**Colorado Springs Airport Advisory Commission Meeting
To Be Heard June 23, 2021
Land Use Review Item #10**

EL PASO COUNTY BUCKSLIP NUMBER(S)/FILE NUMBER(S): VR212 <i>RESIDENTIAL VACATION AND REPLAT</i>		PARCEL #(S): 5509301011, 5509301012, 5509301013, 5509301081
DESCRIPTION: Request by Matrix Design Group on behalf of COLA, LLC for an Administrative plat amendment to the Trails at Aspen Ridge Filing No 1. The amendment adjusts the internal lot lines of 4 lots and 1 tract and creates a replat lots 11-14 to the Trails at Aspen Ridge Filing No. 1A. The property is zoned RS-5000 (Residential Suburban). The property is located southeast of the intersection of Bradley Road and Powers Boulevard. <i>Review Note: The Trails at Aspen Ridge Final Plat was reviewed with recommended conditions by the Commission in February 2019.</i>		
CONSTRUCTION/ALTERATION OF MORE THAN 1 200 FEET ABOVE GROUND LEVEL? No	DISTANCE/DIRECTION FROM COS: 1.8 miles southeast of Rwy 35R	
TOTAL STRUCTURE HEIGHT AT THE ESTIMATED HIGHEST POINT: 30 feet above ground level; 5,950 feet above mean sea level	COMMERCIAL AIRPORT OVERLAY SUBZONES PENETRATED: None

EL PASO COUNTY BUCKSLIP NUMBER(S): SF-19-002 <i>RESIDENTIAL FIN

**THE TRAILS AT ASPEN RIDGE FILING NO.14**  
A SUBDIVISION OF A PORTION OF THE WEST 1/2 OF SECTION 9,  
TOWNSHIP 15 SOUTH, RANGE 65 WEST OF THE 6TH P.M.,  
EL PASO COUNTY, COLORADO  
SHEET 1 OF 3

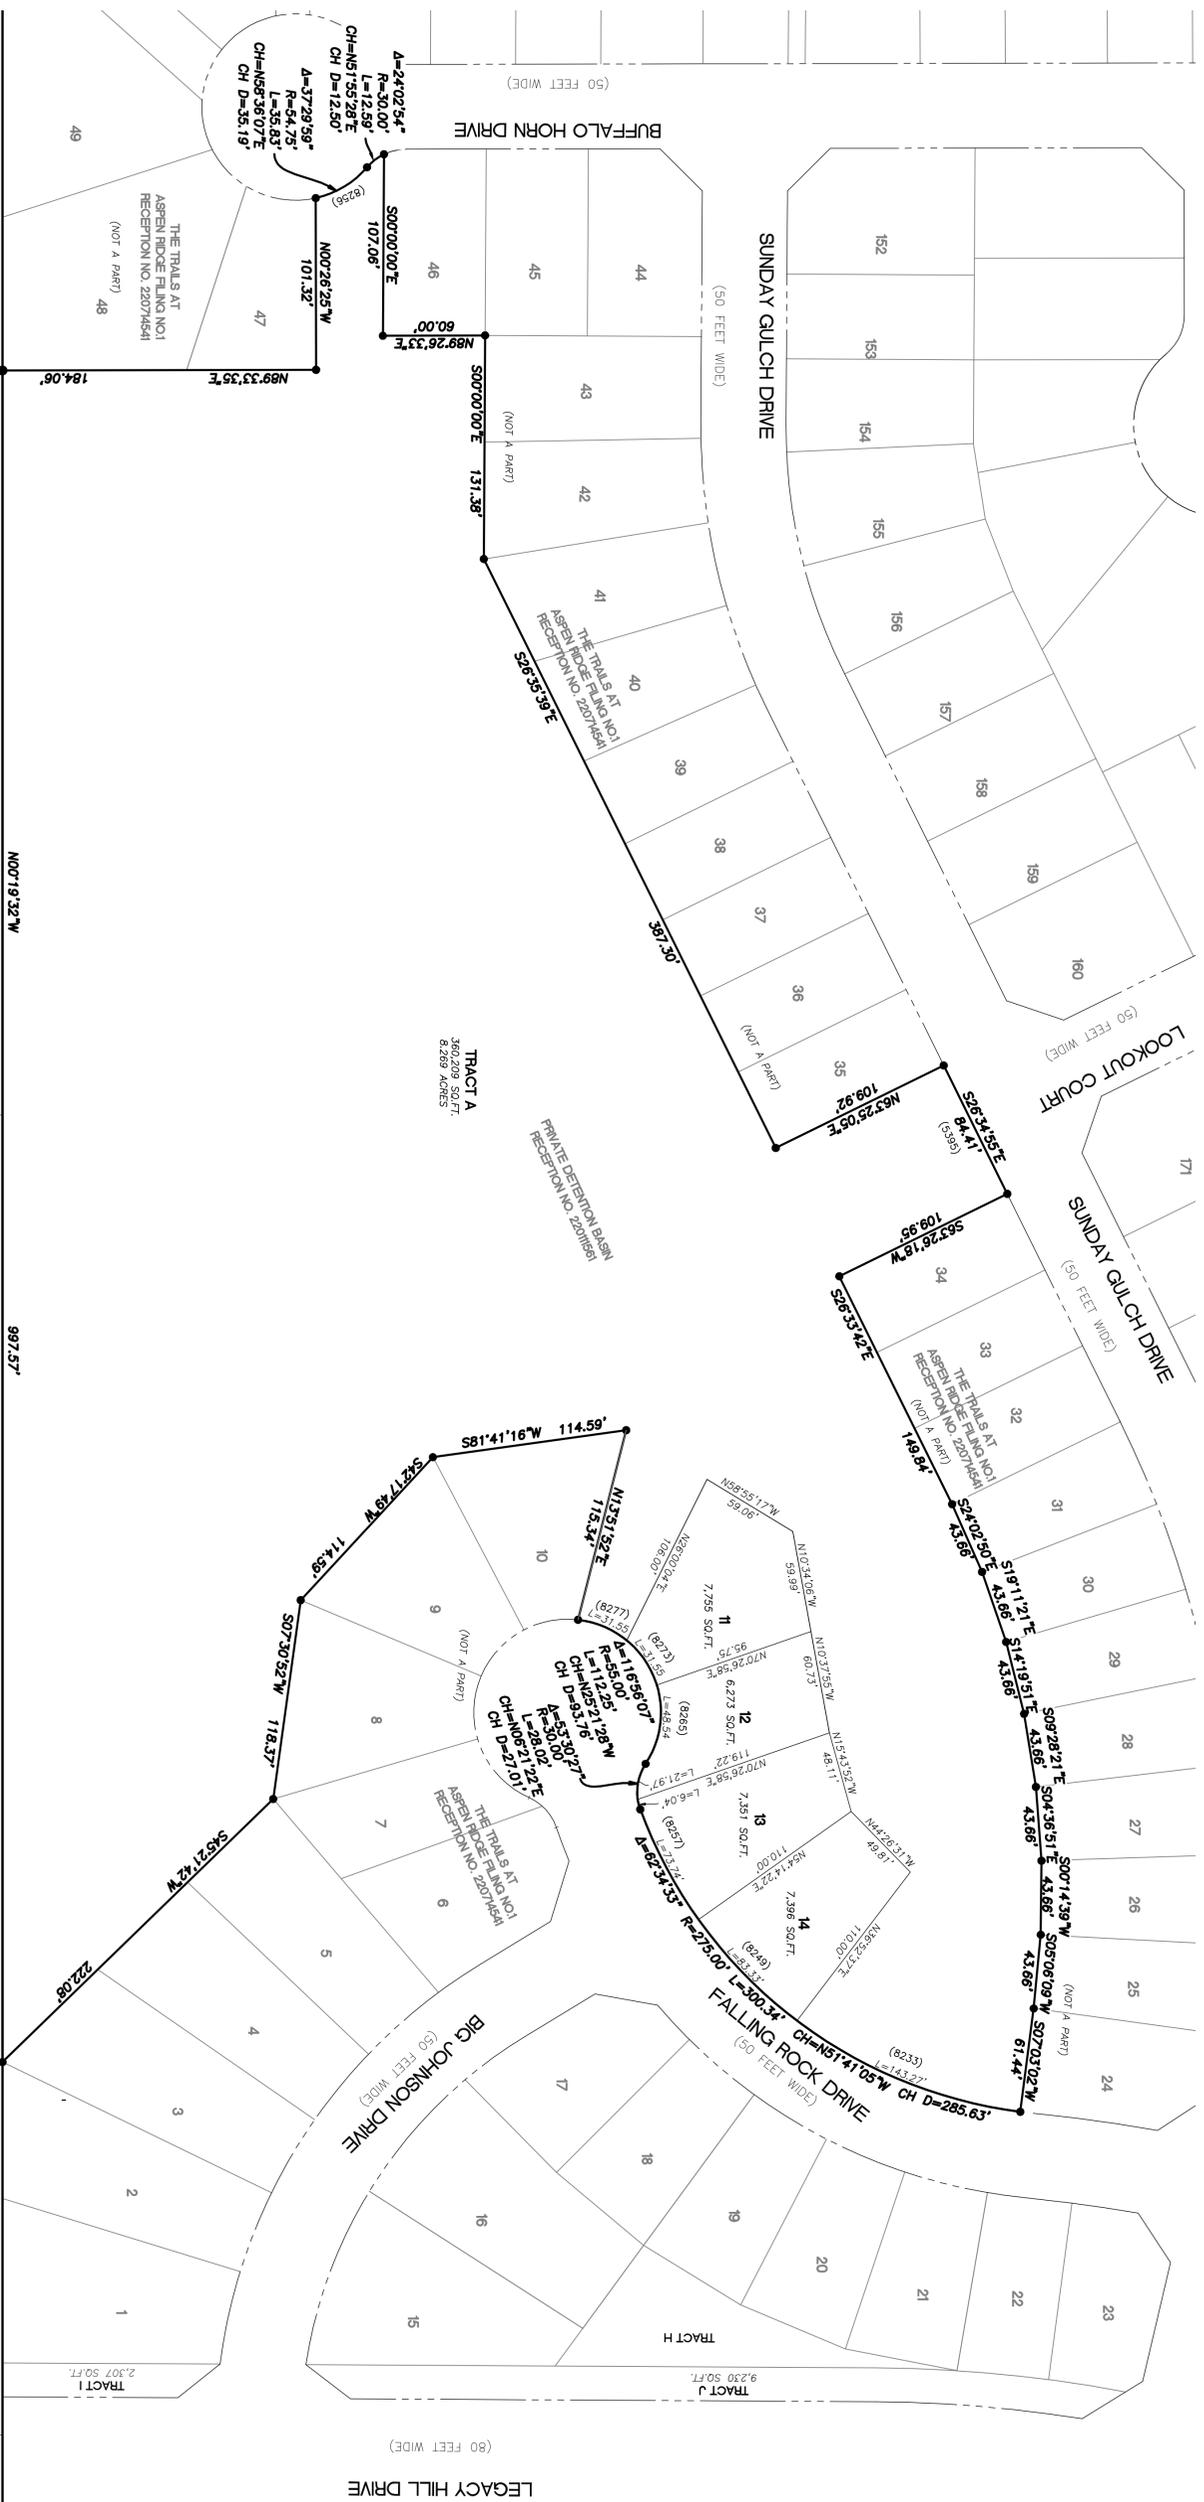
- Remove outdated language under Easements including the following: *No obstructions are allowed to penetrate 40:1 approach surface; All exterior lighting plans are approved by Director of Aviation...*

- Add following previously agreed to language: *The development and its occupants may be impacted by air illumination or approach lighting systems that use medium and high-intensity lights to guide aircraft to the runway centerline used for navigation or flight in air.*

- Clarify “The applicant shall voluntarily make a 30-DB reduction in exterior noise...” per note no. 11.
- Based on elevation data, the applicant will need to file Federal Aviation Administration (FAA) Form 7460-1 “Notice of Proposed Construction or Alteration” for any new vertical development at this site, including temporary construction equipment, and provide FAA documentation to the Airport before the commencement of construction activities.
